From: Amanda Scholes on behalf of Planning.Responses
Sent: 12 April 2018 09:04
To: Planning Scanning
Subject: FW: A/142/17/PL

From: Paul Cann
Sent: 11 April 2018 11:34
To: Andrew Wood
Cc: Laura Gibbons
Subject: RE: A/142/17/PL

From: Andrew Wood
Sent: 11 April 2018 10:59
To: Paul Cann
Cc: Laura Gibbons
Subject: A/142/17/PL

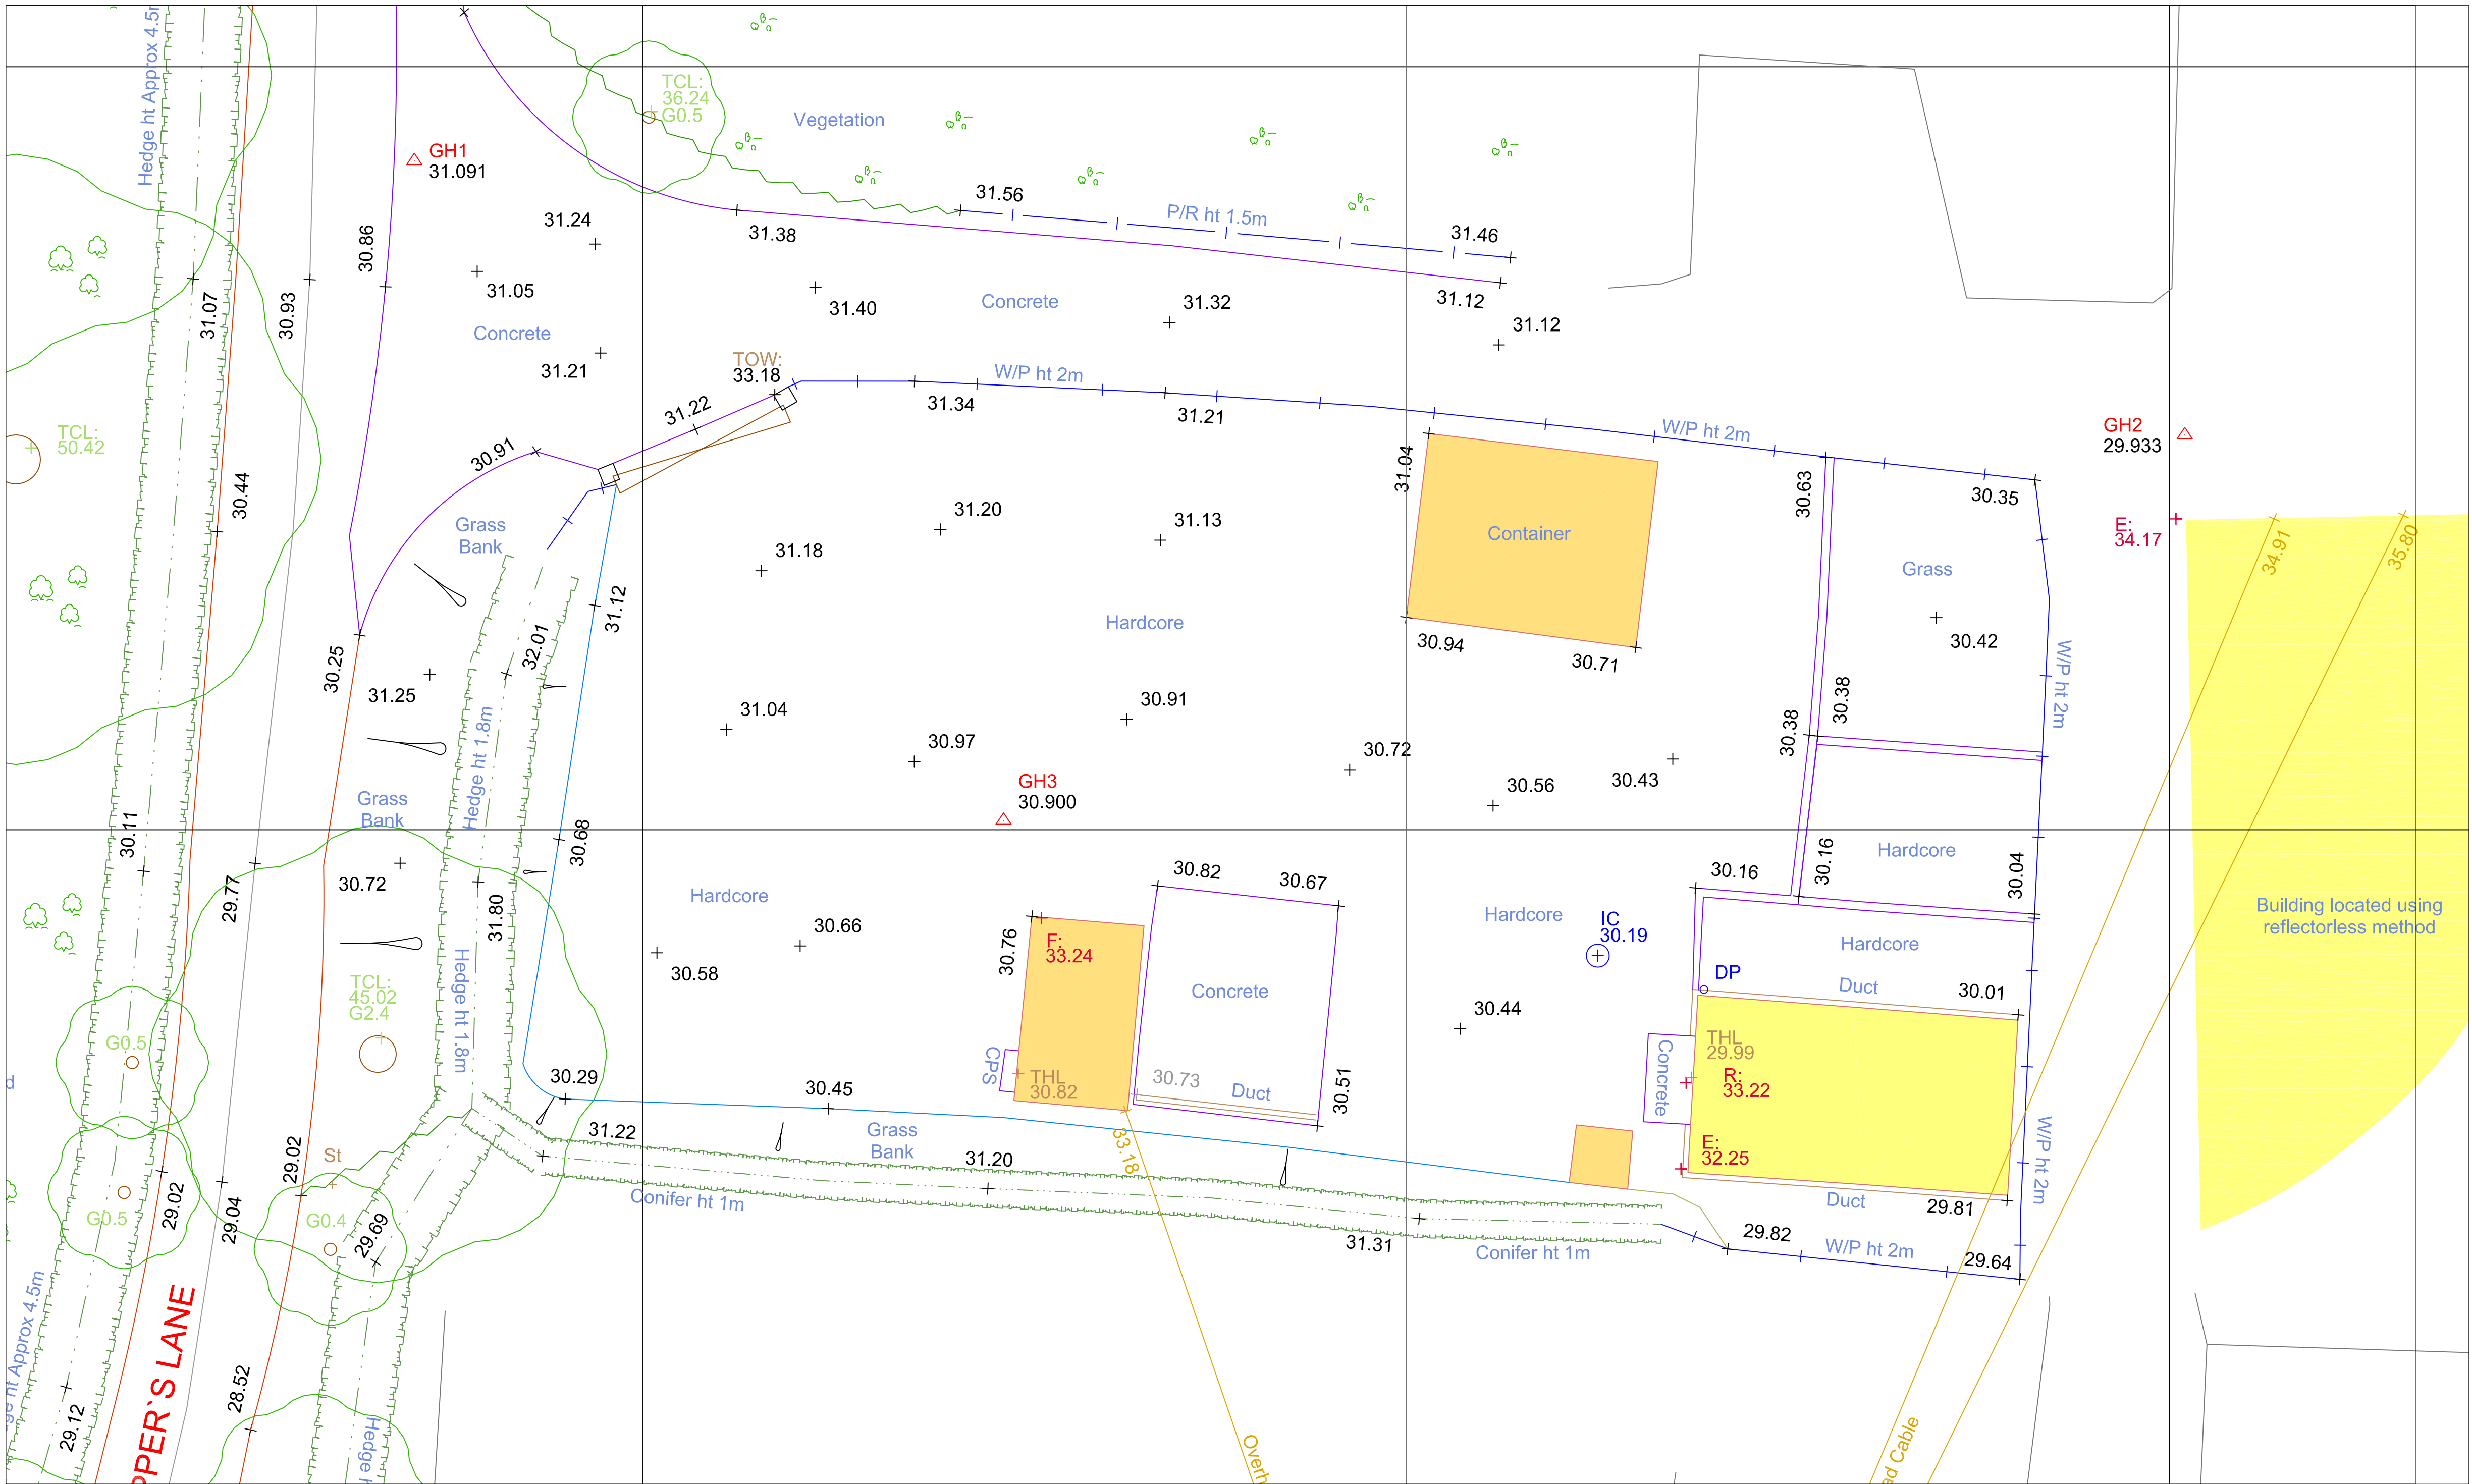
Having looked at their plans, it is noted that the application will not make any improvements to the current surface water runoff arrangements on site, whereby surface water run-off is likely to be shed onto Dappers Lane in certain storm events, which in turn causes issues in Angmering village. The removal of vegetation could add to these issues, although they are also undertaking some replanting.

Therefore, if they can be encouraged to try and improve their surface water arrangements on site, it can only be a good thing, as well as help provide further compensation for the loss of hedgerows.
